CITY OF ALBUQUERQUE

**Planning Department
Transportation Development Services Section**

November 23, 2010

Re: Certification Submittal for a Permanent Building Certificate of Occupancy
(C.O.) for Accion Regional Headquarters, [H-13 / D023]
2000 Zearing NW
Engineer's Stamp Dated 11/22/10

SITE PLAN
1" = 20'

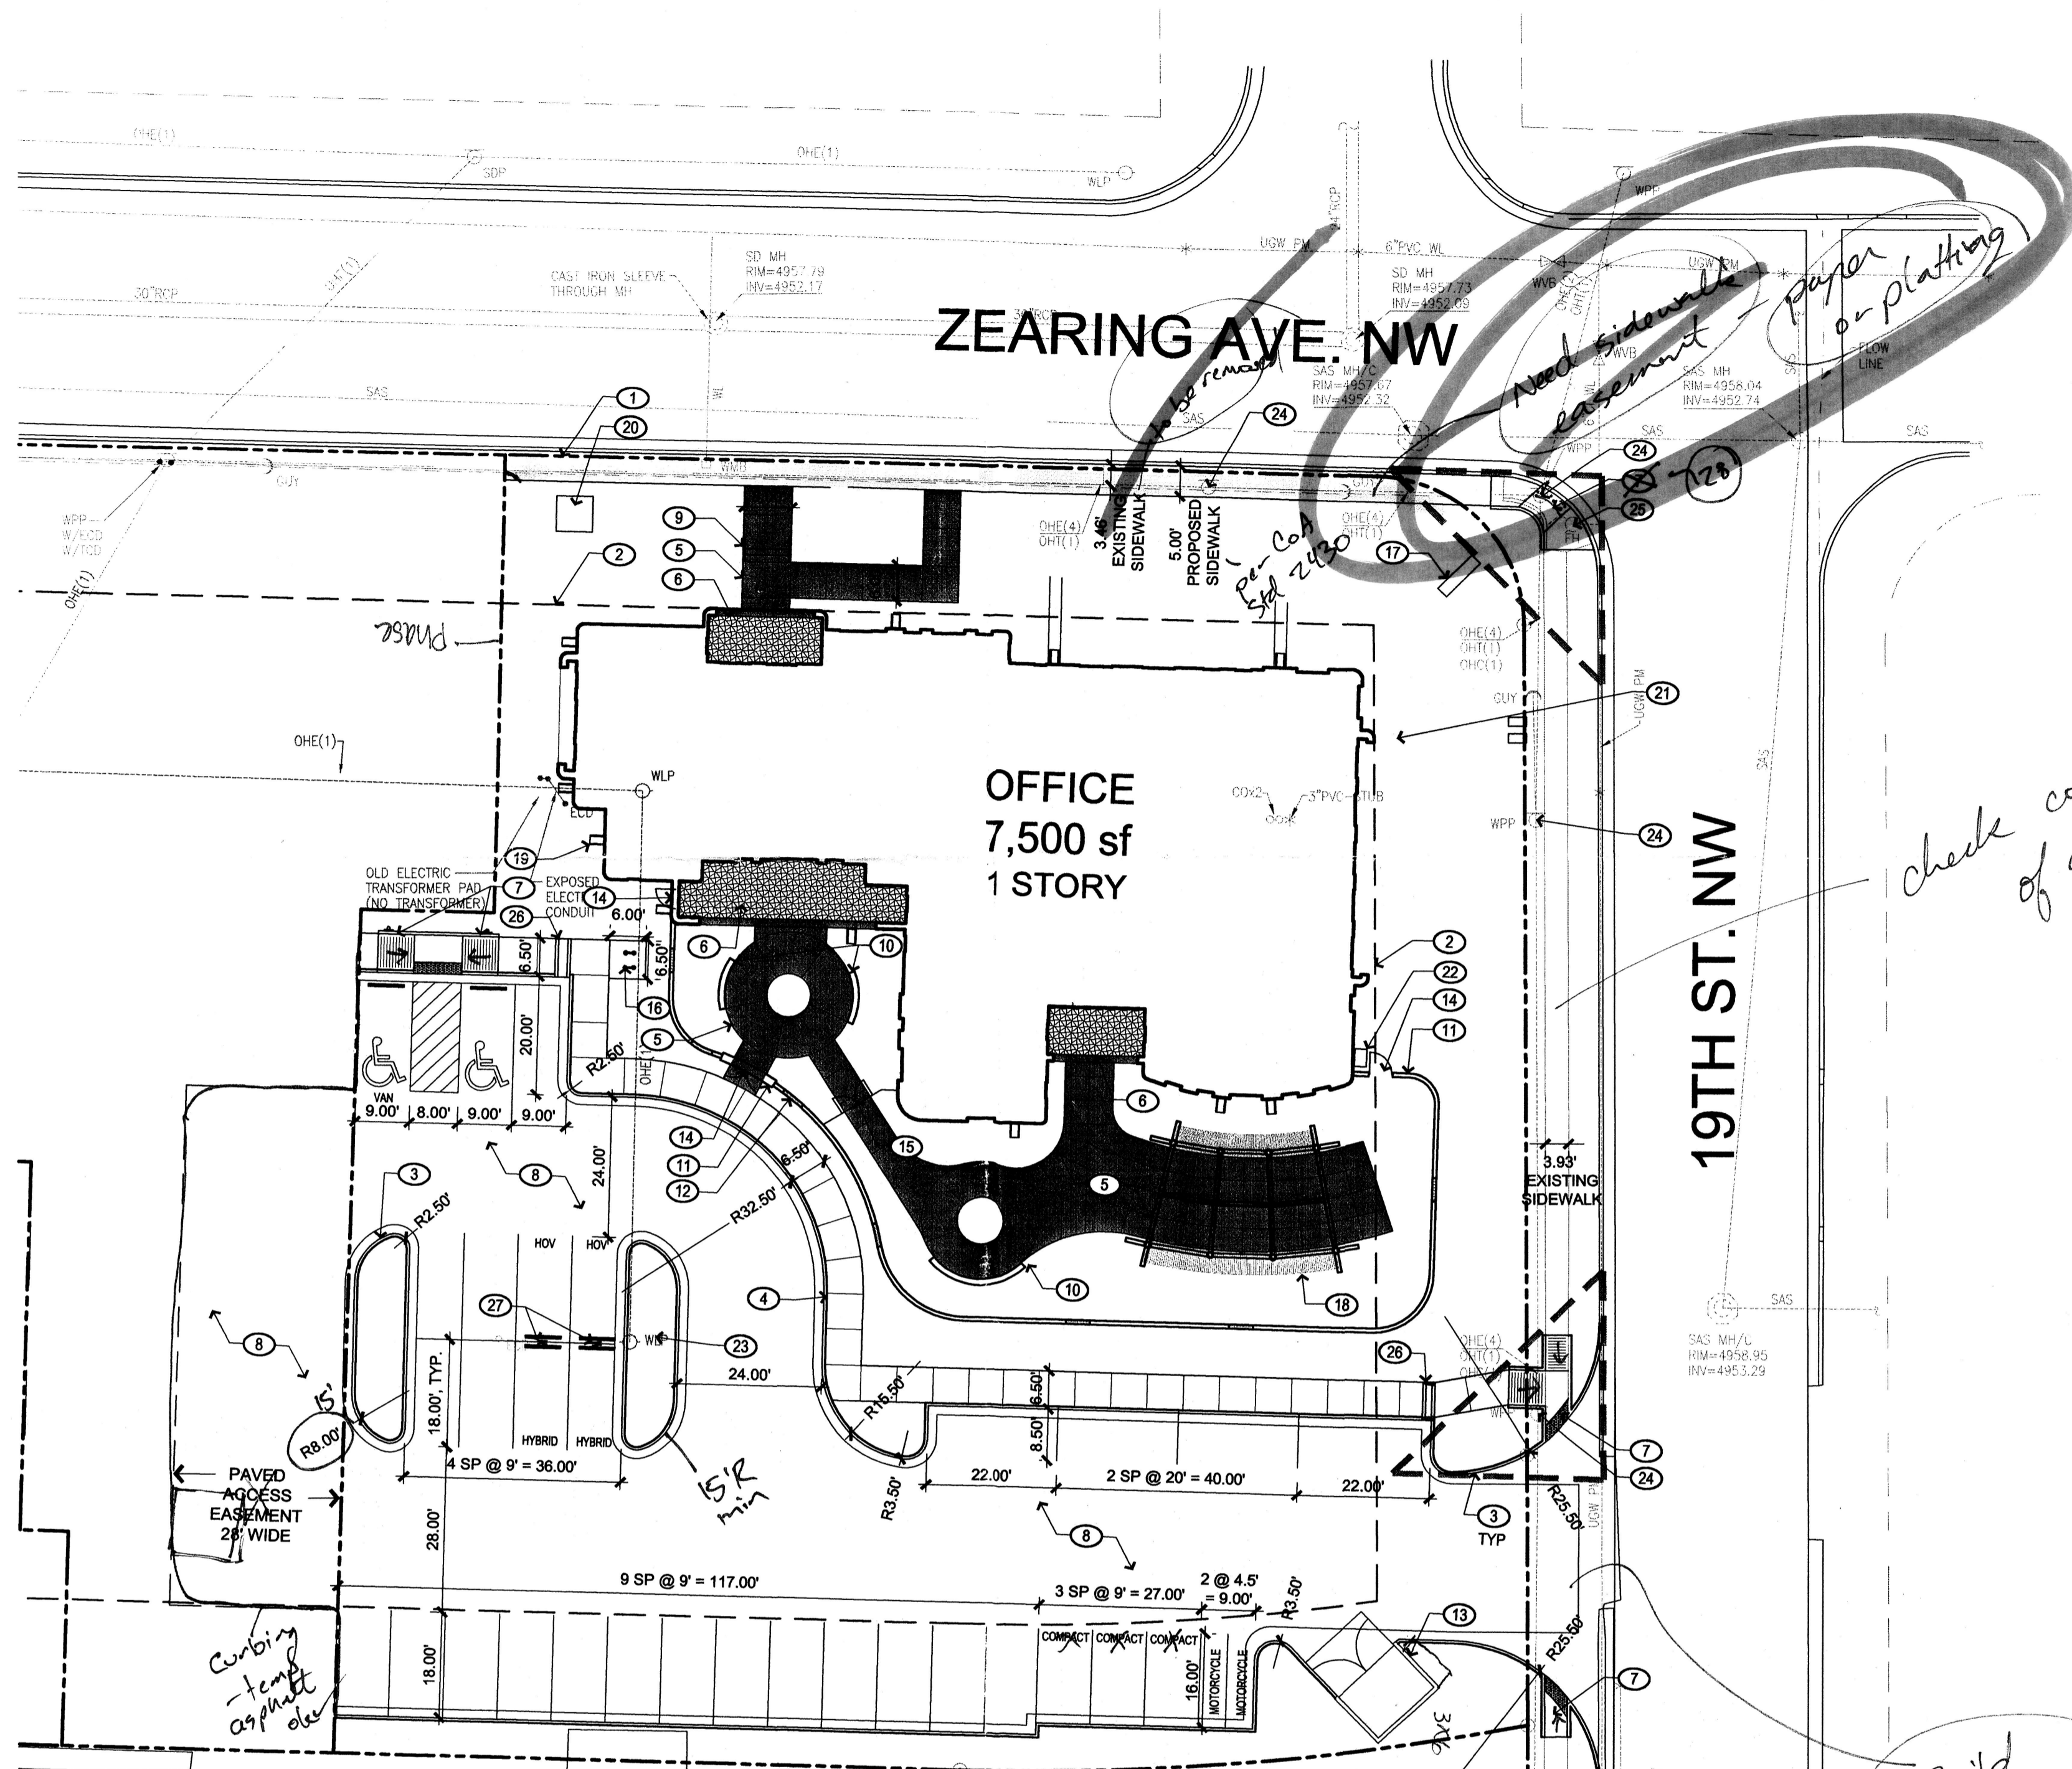
1. A steel parking trellis was added over the central parking island. A photovoltaic system was also added to the project and is mounted to the top of the trellis. This system was separately permitted through the City of Albuquerque.
2. There is a jog in the sidewalk adjacent to Zearing Avenue so that it can avoid the existing utility pole and support cable on the north side of the building.
3. The accessible ramp at Zearing Avenue and 19th Street was redesigned because it did not meet city standard detail #2441 as noted on the site plan.

Mr. Bob Peterson, you'll need to contact your designer (Christopher Gunning/Kevin Kofchur) for the issues stated on the letter dated September 2, 2010. Mr. Gunning will need to address these issues. The ramps don't meet COA STA DWg 2441 not 2431, thank you.
Nilo Salgado-Fernandez

The following items will need to be addressed prior to issuance of a Permanent Certificate of Occupancy: Wheel Ramp at the corner of Zearing and 19th doesn't comply with ADA or City of Albuquerque Standards (will need to be corrected to comply); the sidewalk obstruction doesn't follow COA STD DWG 2431 design (you'll need to redline and show As-builts of the current design on the Site Plan . Once these issues have been addressed you'll need to re-submit the total package for Permanent C.O.
